File No: NTH24/00543/004
Your Ref: SSD-70748466 - PAE-100162207

Advice on Assessment for Huntlee New Town - Stage 2 - Wine Country Drive, Rothbury

SSD-70748466 - Advice on RTS - Huntlee New Town - Stage 2 - Wine Country Drive Rothbury

RE: Review of Environmental Impact Statement (SSD-70748466) - Advice on EIS - Huntlee New Town - Stage 2 - Wine Country Drive Rothbury

DRAWING TITLE
CONCEPT CIVIL
ENGINEERING PACKAGE
INTERSECTION A-11 - CIVIL WORKS
PLAN - SHEET 2

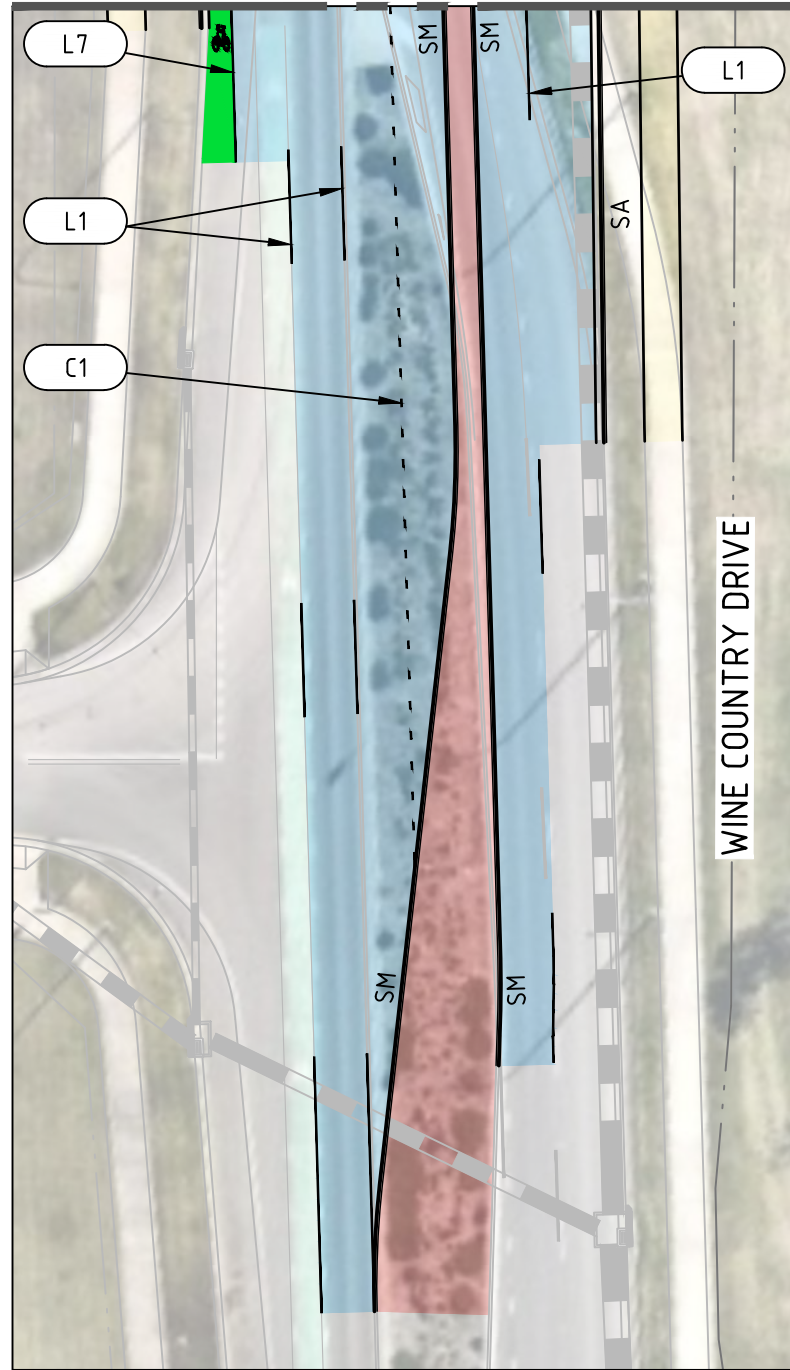
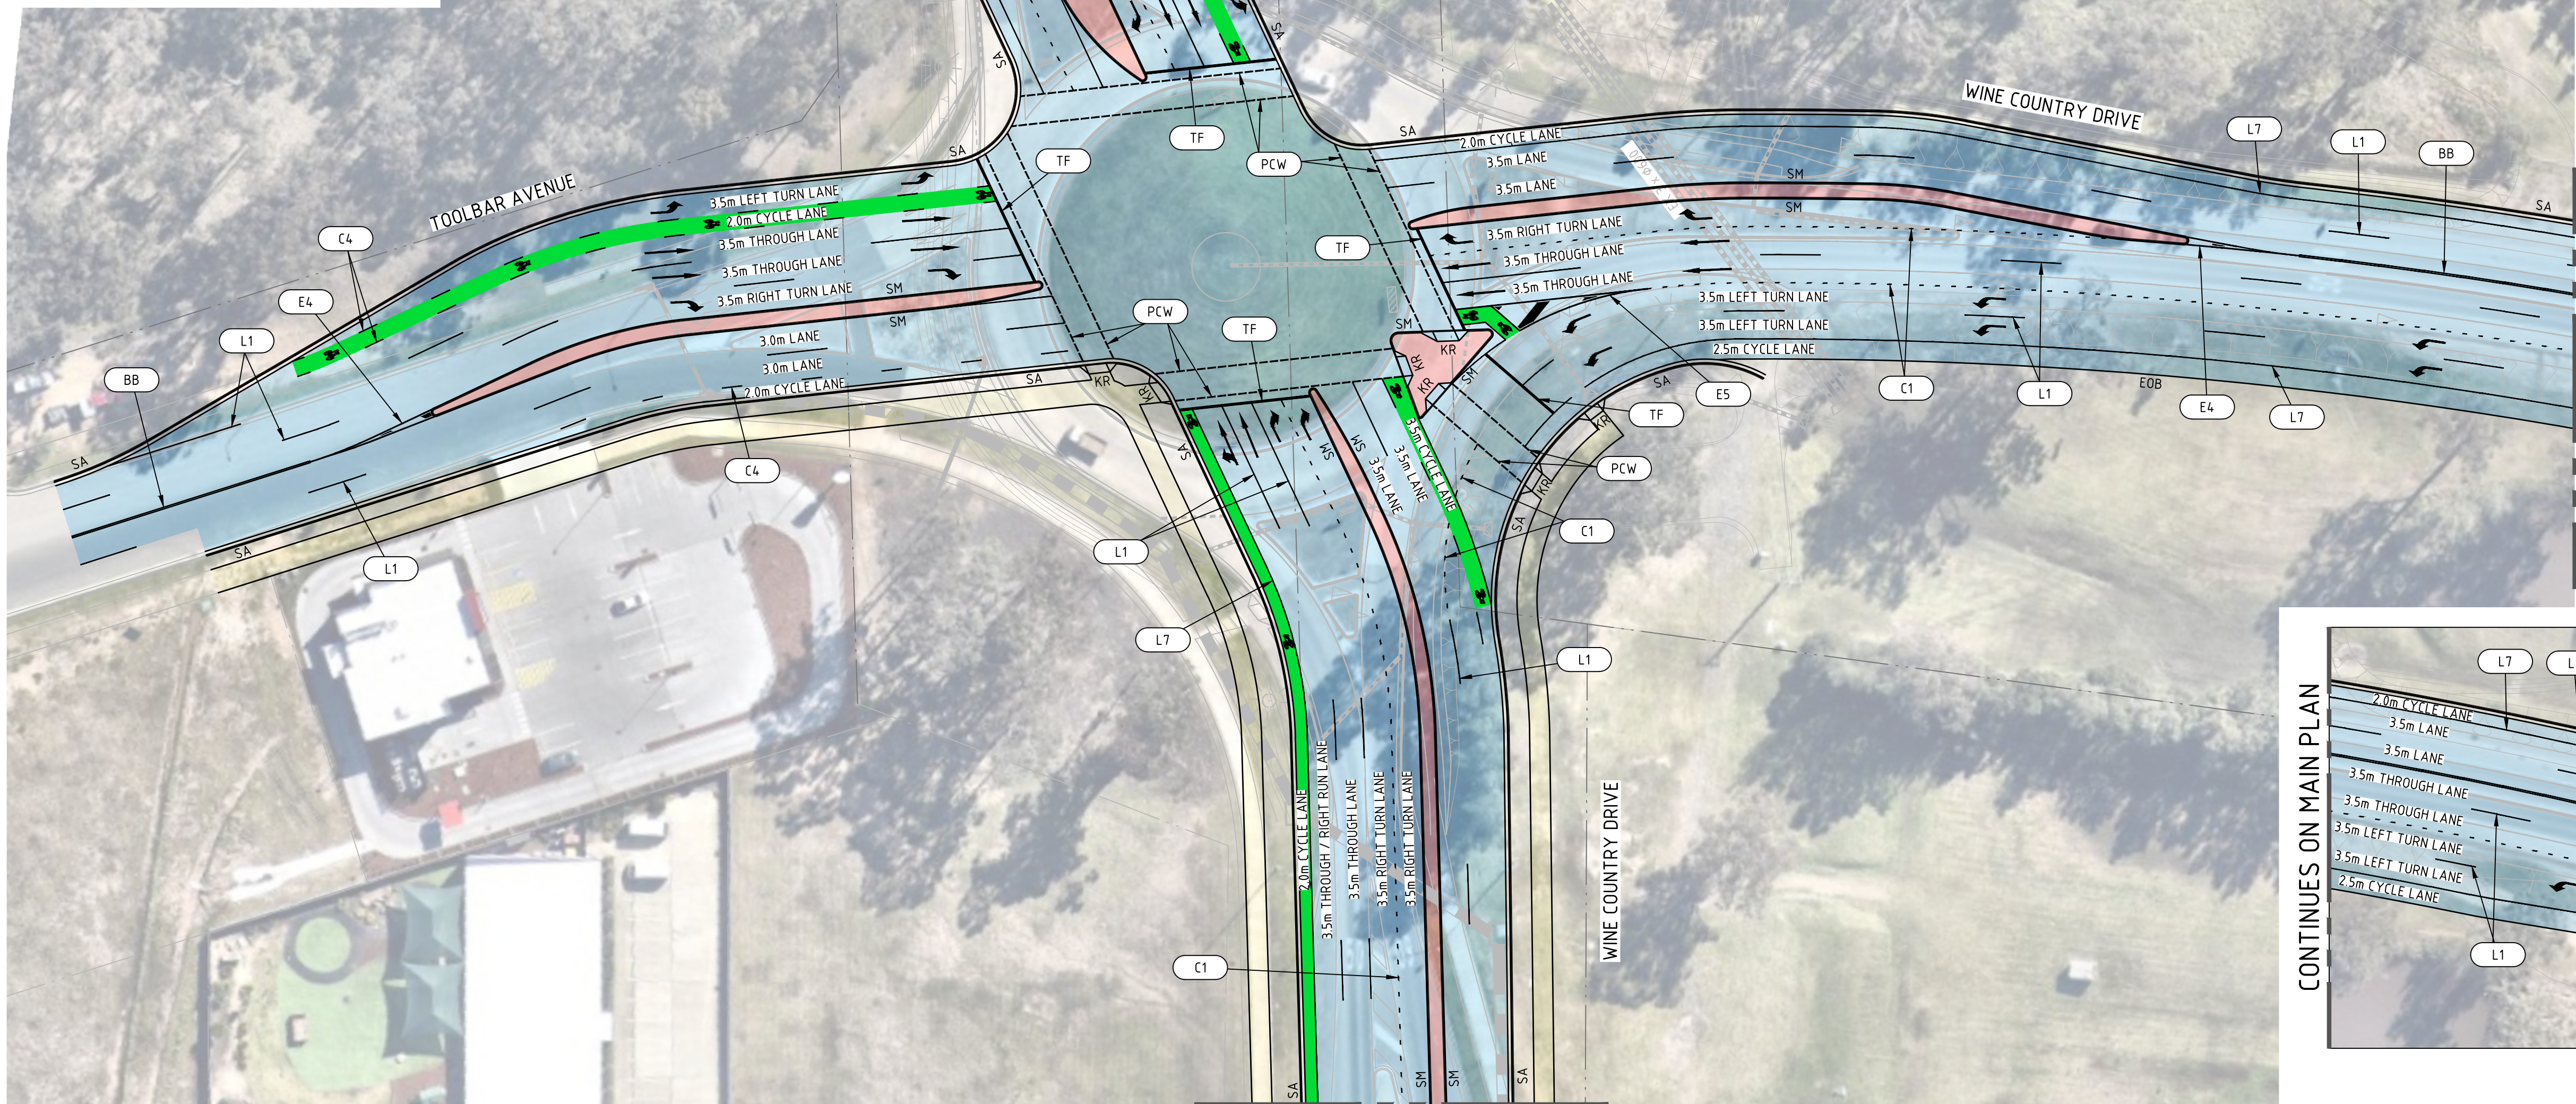
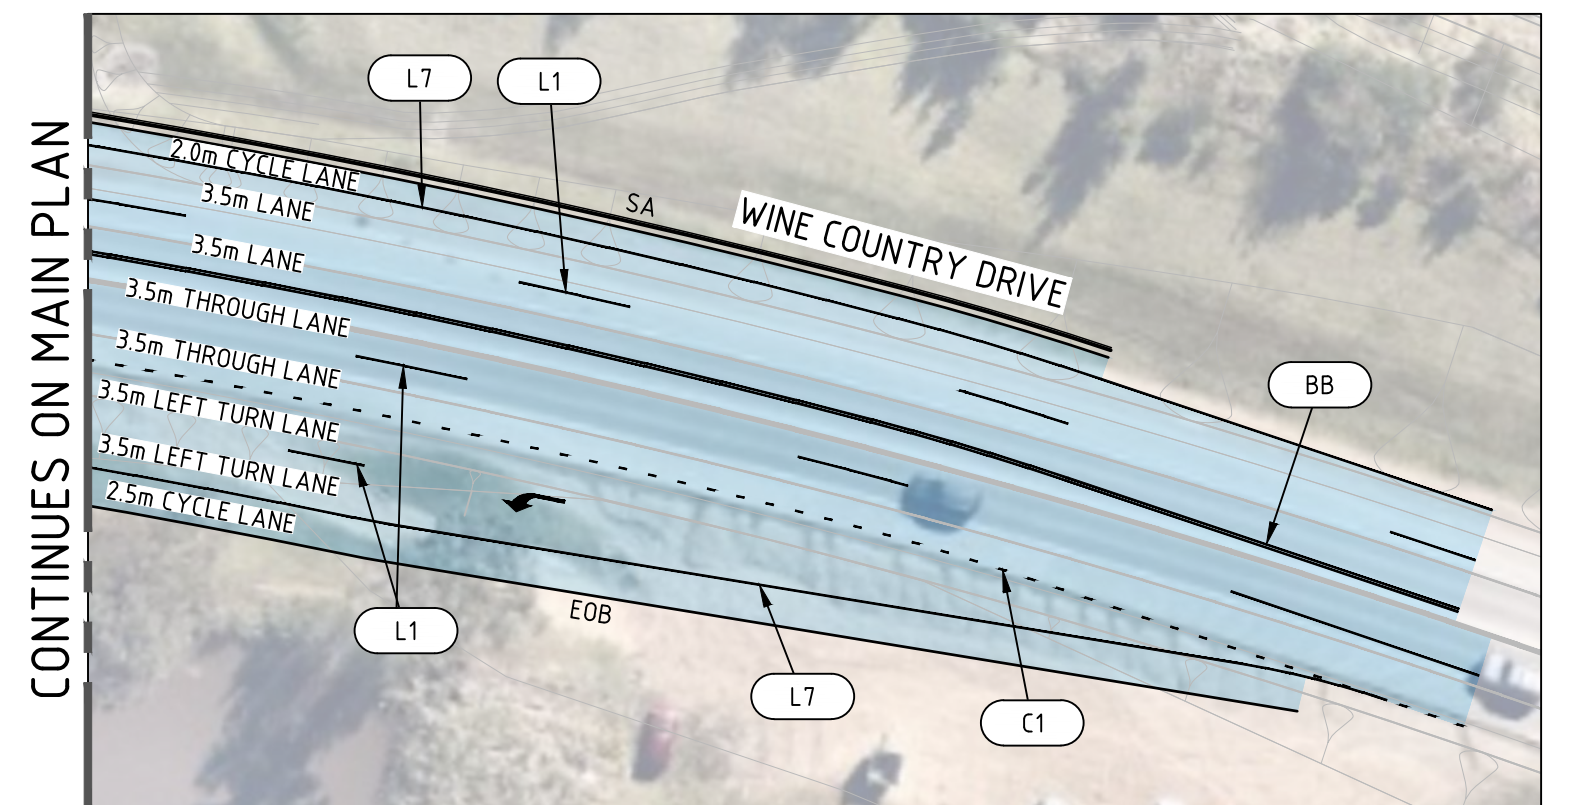
- Road Design (A-11)
 - Please show the current WAD for the slip lane, TCS and duplication on the current drawing set.
 - No pavement arrows are shown to illustrate the intended double right turn.

- The additional lane and merge on the ramp are inconsistent with recommendations from AGRD part 4C section 11.3.3 and table 11.2.
 - Runout area in accordance with AGRD is required at the end of merges where the shoulder is less than 2.5m

- Where the new slip lane joins the existing westbound highway entry ramp, the raised island nose should run parallel for 10m after the tangent to force a parallel merge in accordance with AGRD 4a figure 8.7. In this area, a space is also required for cyclist to cross with care. See image below titled 'Figure 8:7 Rural CHL treatment with an acceleration lane'.

- Cams may be required on the new roundabout slip lane.
- The start of the roundabout slip lane is less than the minimum diverge length required for the design speed.
- Can the start of the left turn slip lane be seen at the design speed on the inside of the curve?

DRAWING TITLE
CONCEPT CIVIL
ENGINEERING PACKAGE
INTERSECTION A-X - CIVIL WORKS
PLAN - SHEET 1

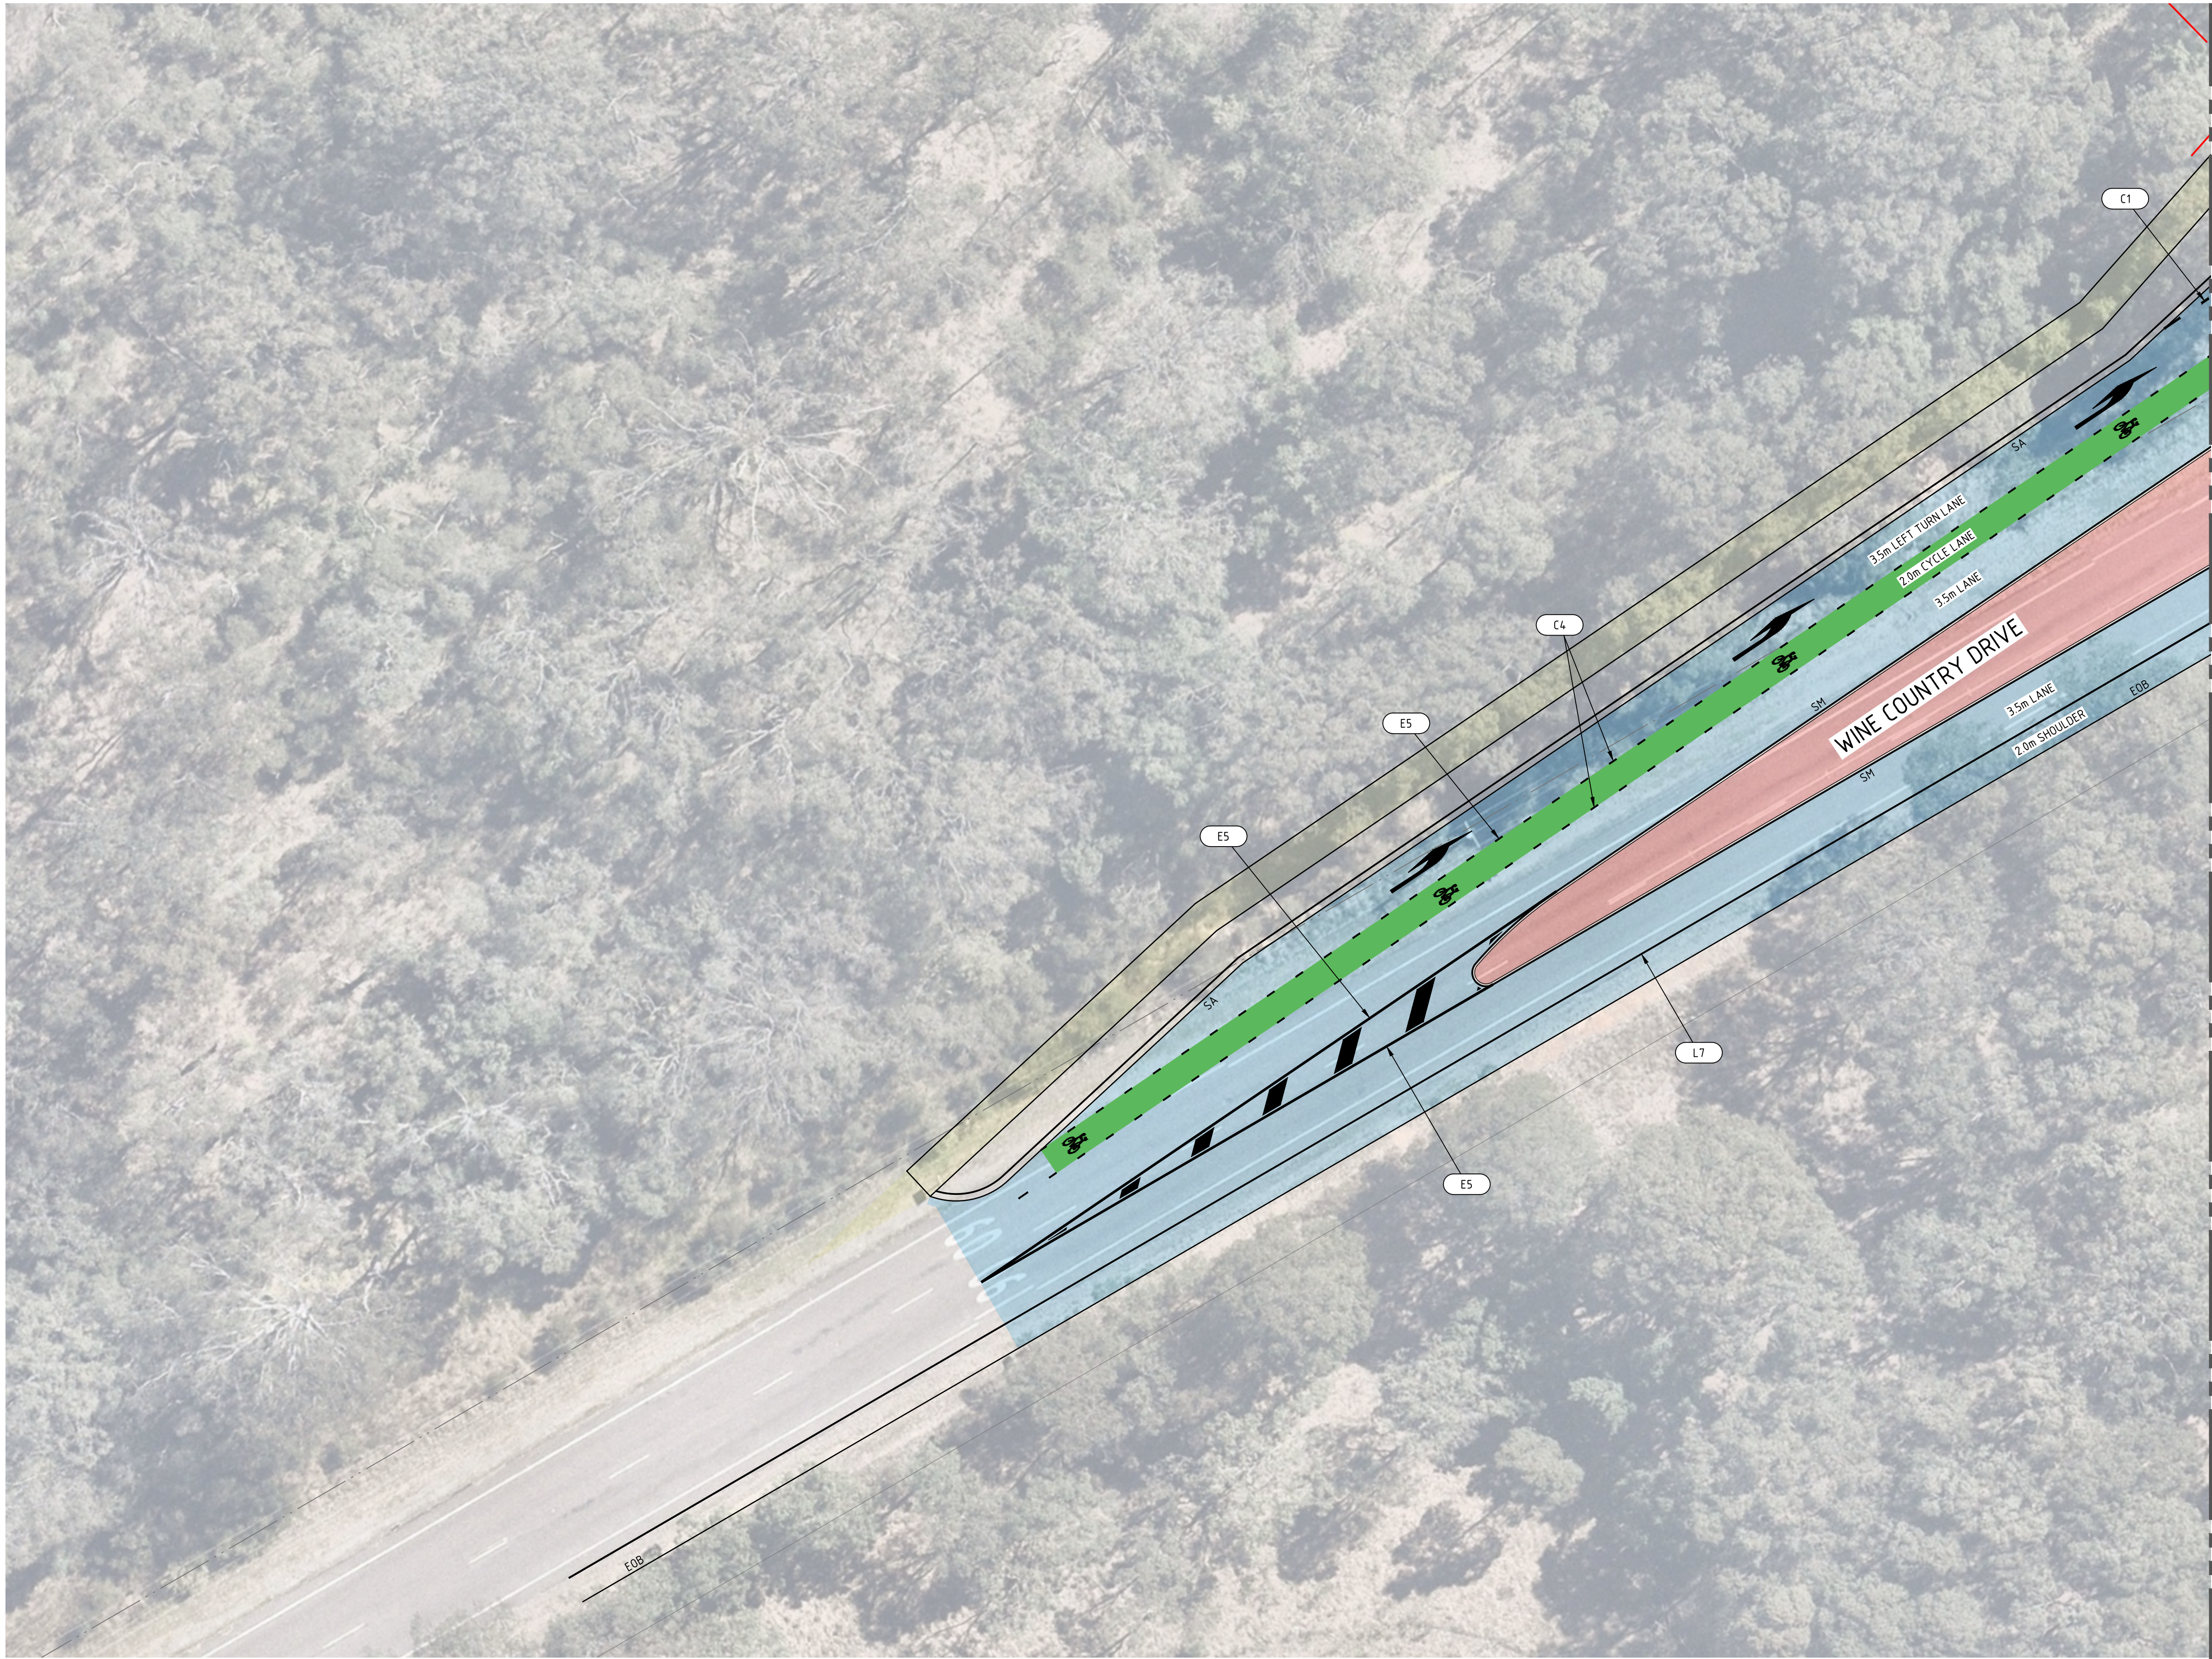
- Road Design (A-7 aka A-X)
 - Safe Intersection Sight Distance (SISD) should be considered at design speed i.e. posted plus 10km/hr and demonstrated, with 3d data provided to prove that adequate sight distance is available (also refer <https://elevation.fsdf.org.au/>)

- The new intersection into the Collector Street should have a median in WCD as there is not enough width to pass a right turner.
 - Then designer should consider a AUL or AUL(s) into the new street.

- Consideration of access to the bus stops on either side of WCD should be considered. A refuge may be required on the crest near the Collector Street assuming pedestrian sight distance is in accordance with Austroads recommendations. Pathways should be connected to the refuge and bus stops.

- The right turn out of Thomas and Mitchel Streets will become increasingly difficult, particularly due to the additional traffic to and from Huntlee and the crest at the Collector Street.

- Does the current heritage plaque need to remain in its current location? If so, is there need for barriers etc.?
 - How will this integrate with future intersection A-8?
